Reference No:	<b>2023/62/93724/E</b>
Site Address:	3, Knowler Hill, Hightown, Liversedge, WF15 6PH
Description:	Erection of first floor rear extension with external alterations
Recommending Officer:	Nicole Helliwell

## **Officer Report**

**Reference No.** 2023/62/93724/E

**Proposal:** Erection of first floor rear extension with external alterations

Drawing Title
PROPOSED

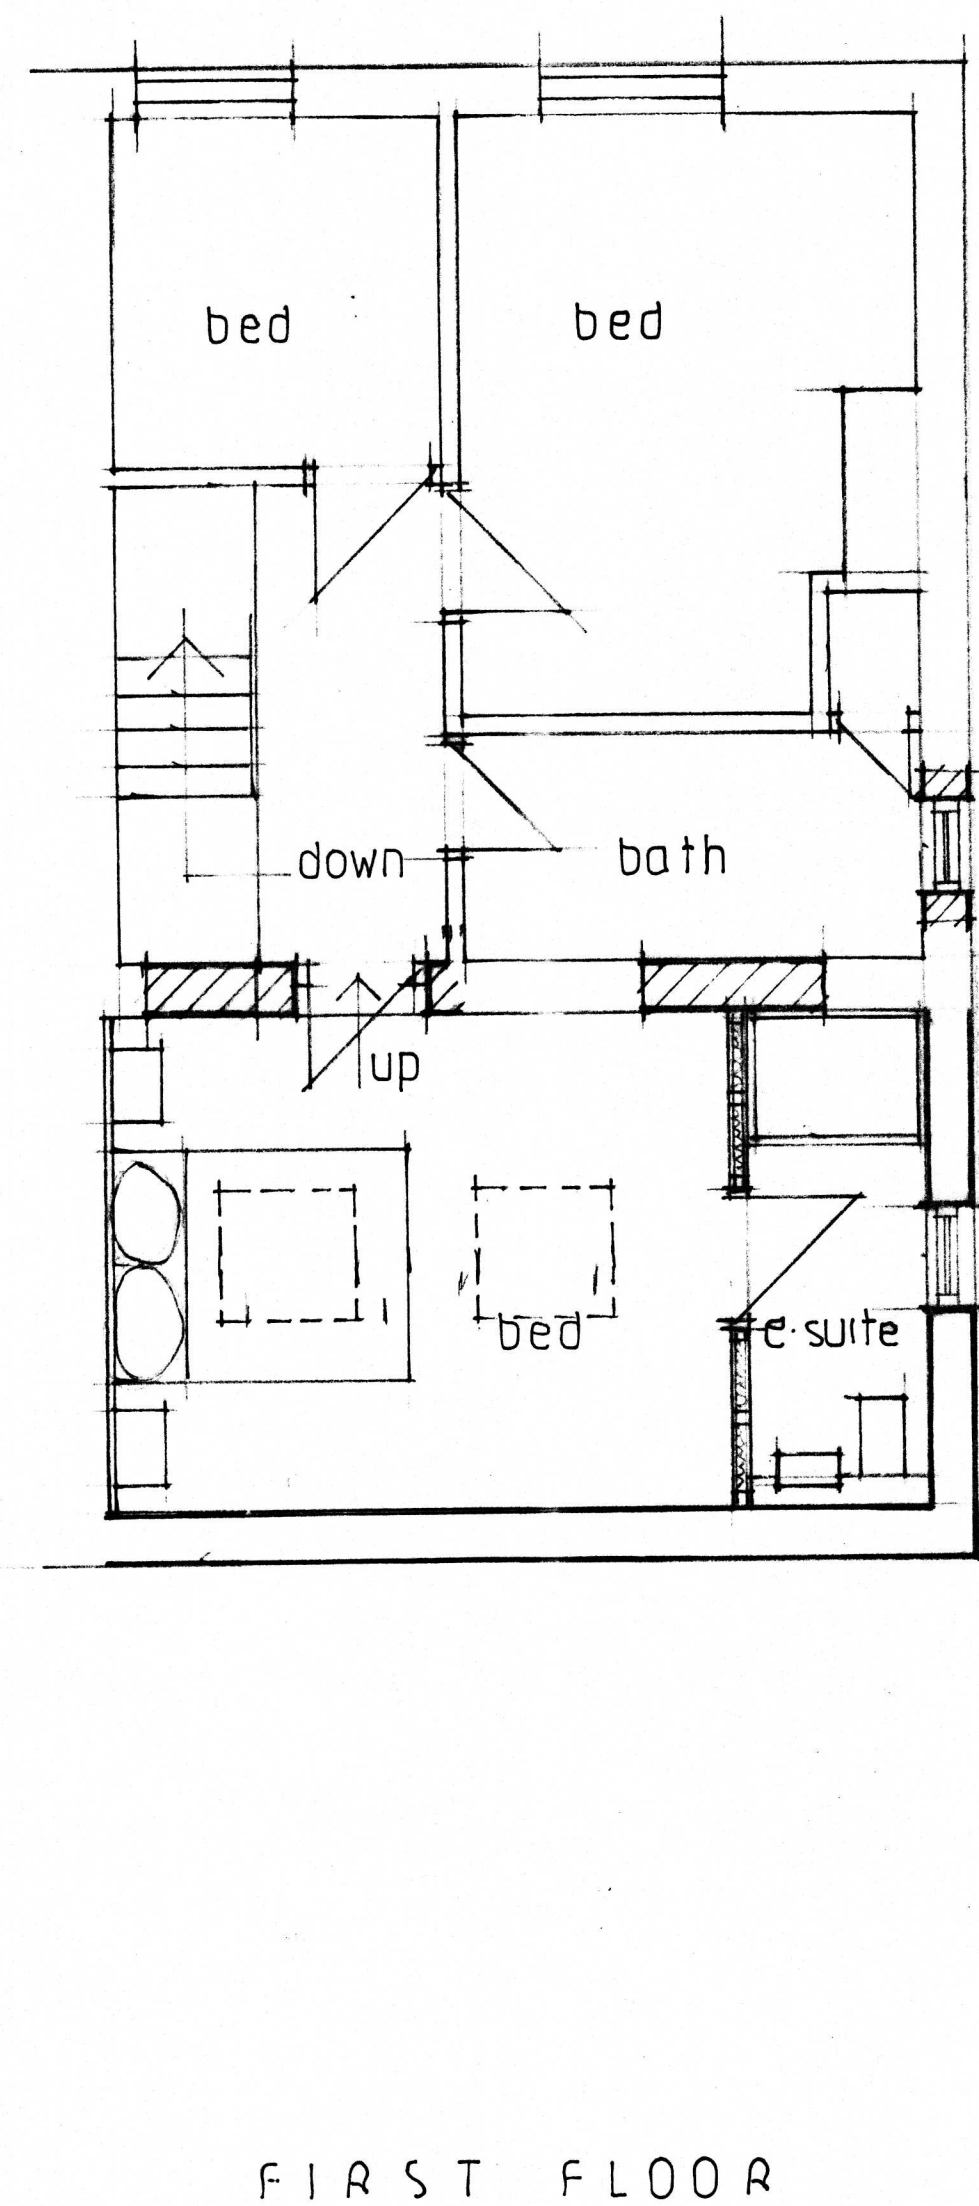
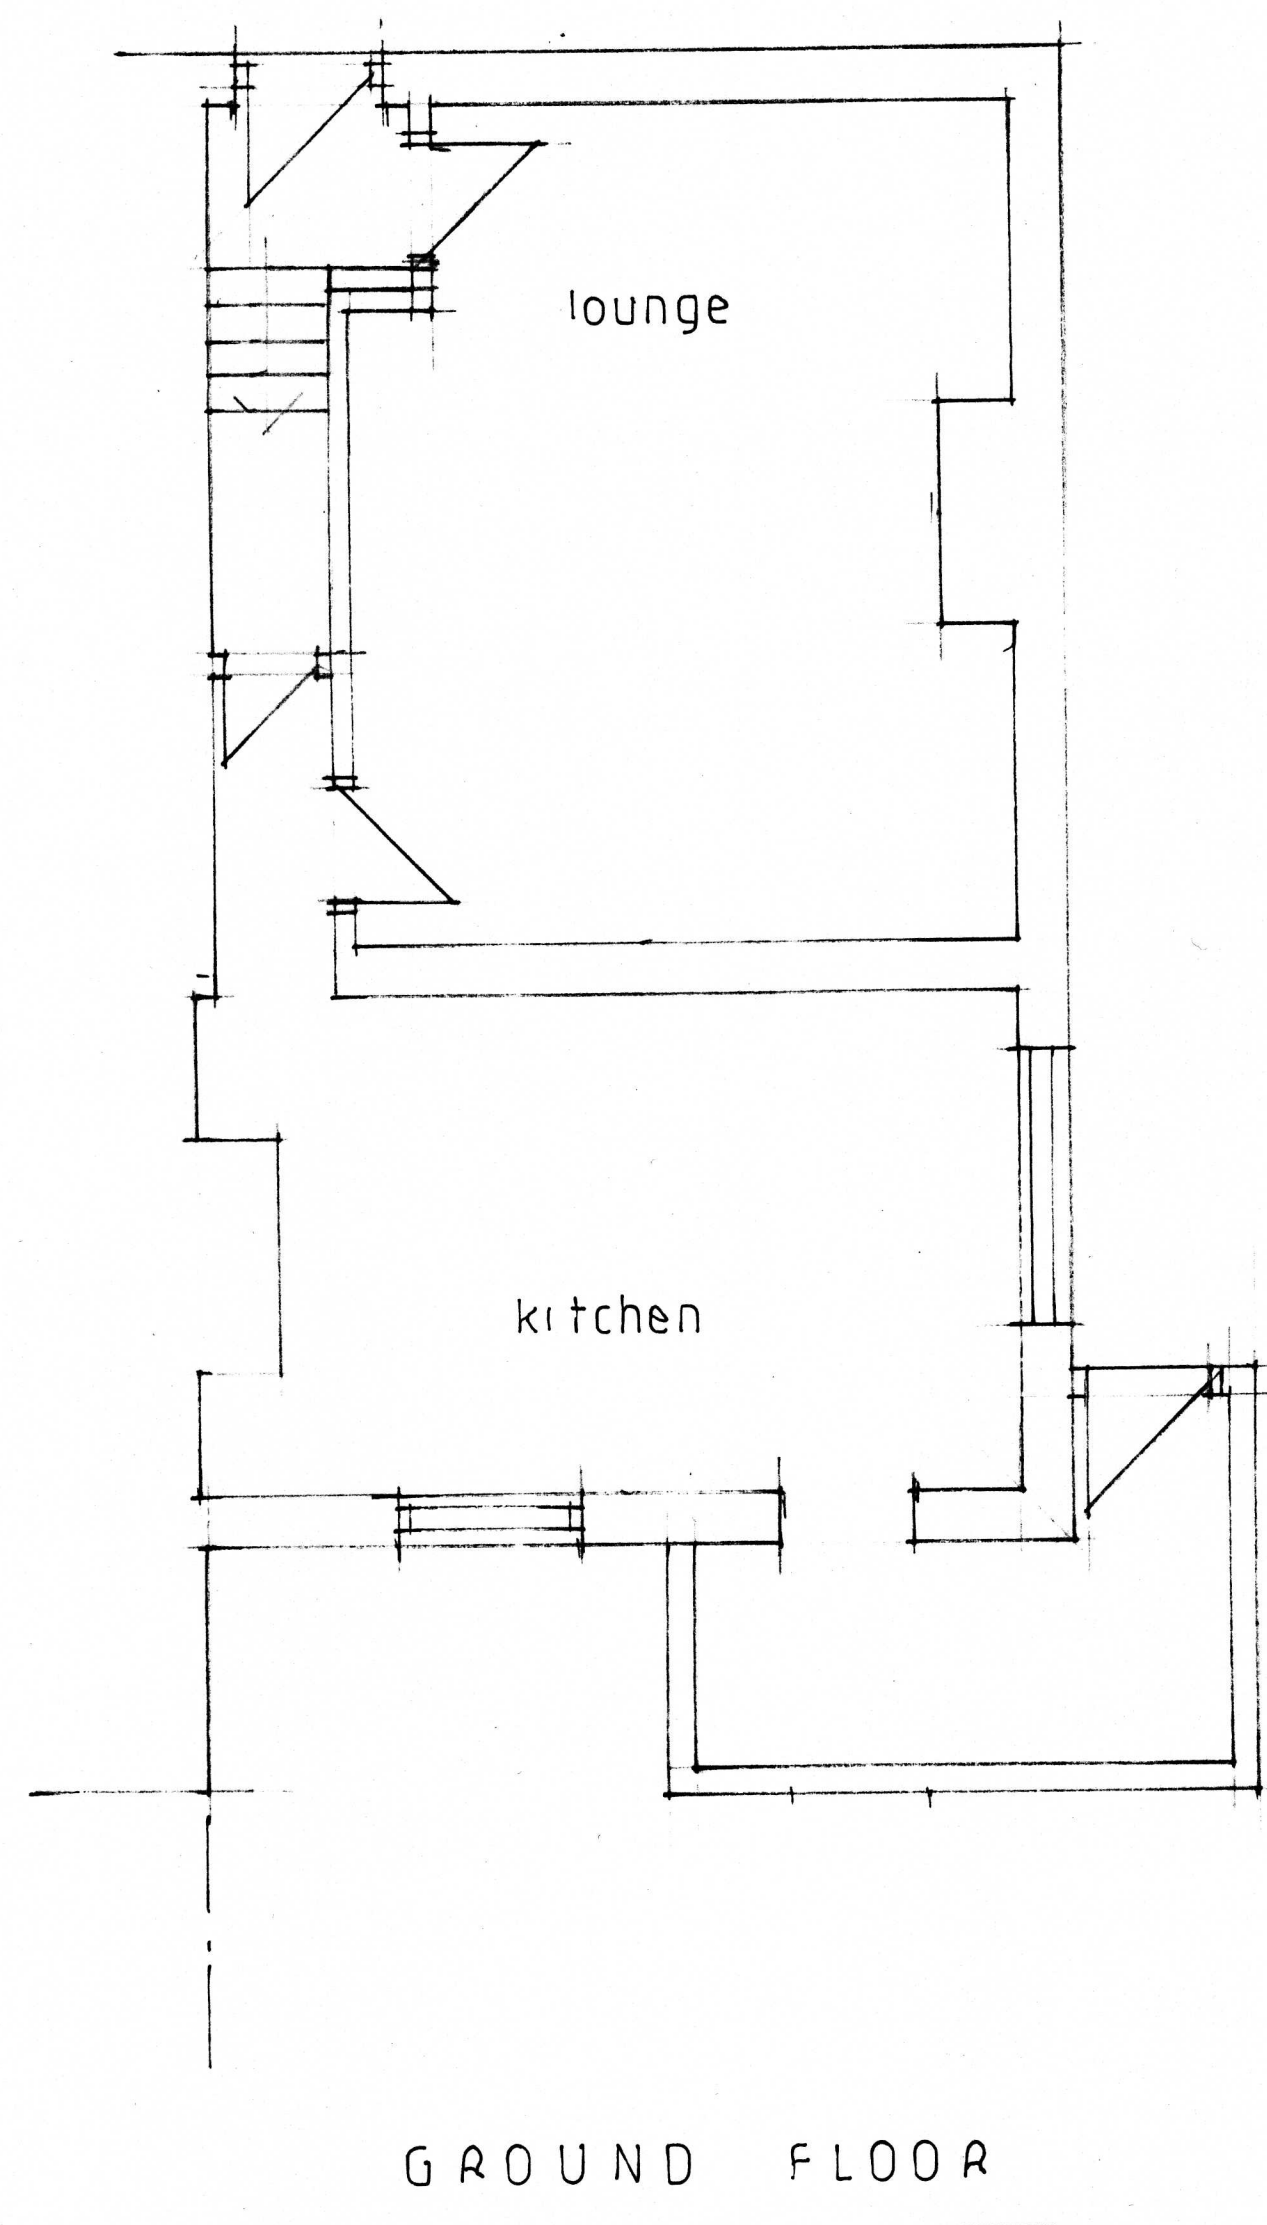
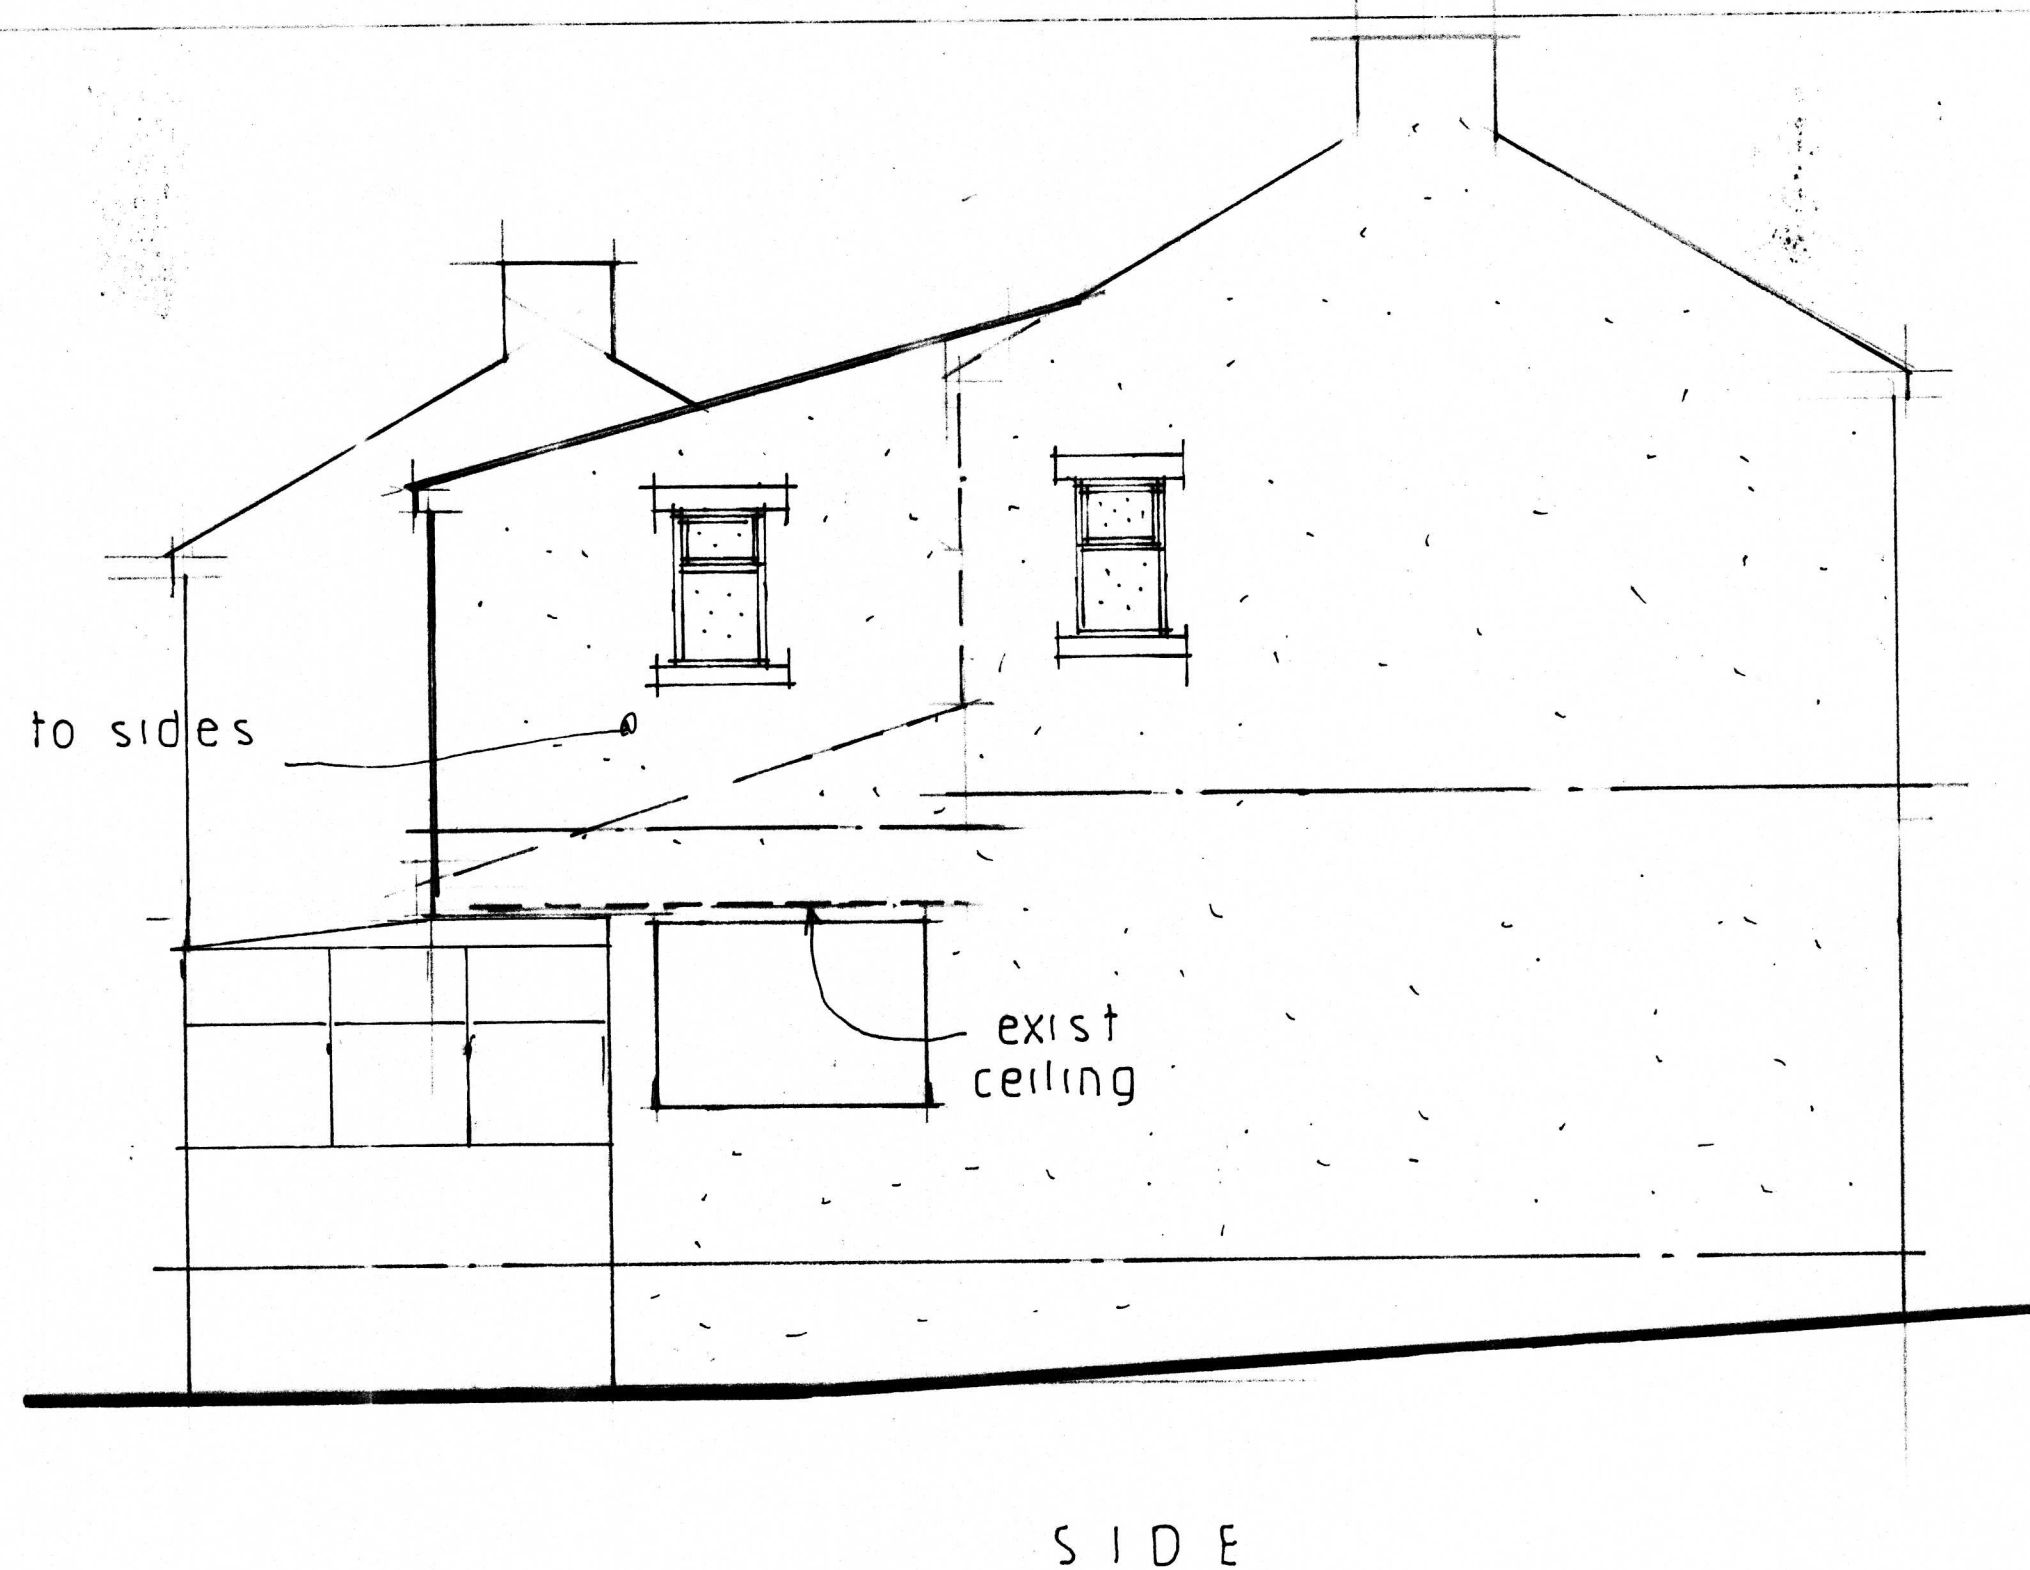
Amendments were sought during the course of the application. A request was made to alter the materials proposed for the side elevation of the extension to red brick to match the appearance of the original build. Furthermore, a request was made to install a first floor window within the rear elevation of the enlargement to improve the occupier's residential amenity. Revised drawings were received which were considered acceptable with regard to visual and occupier amenity.

3. The extension hereby approved shall be faced in render for the external walls with the exception of the side elevation which will be faced in red brick. The roofing materials will also be slate. The materials of construction shall thereafter be retained for the lifetime of the development.

4. The proposed first floor windows in the side elevation of the dwelling shall be fitted with obscure glazing to at least Level 3 on the Pilkington Scale and non-

opening to a height of no less than 1.7m above floor level and retained as such thereafter.
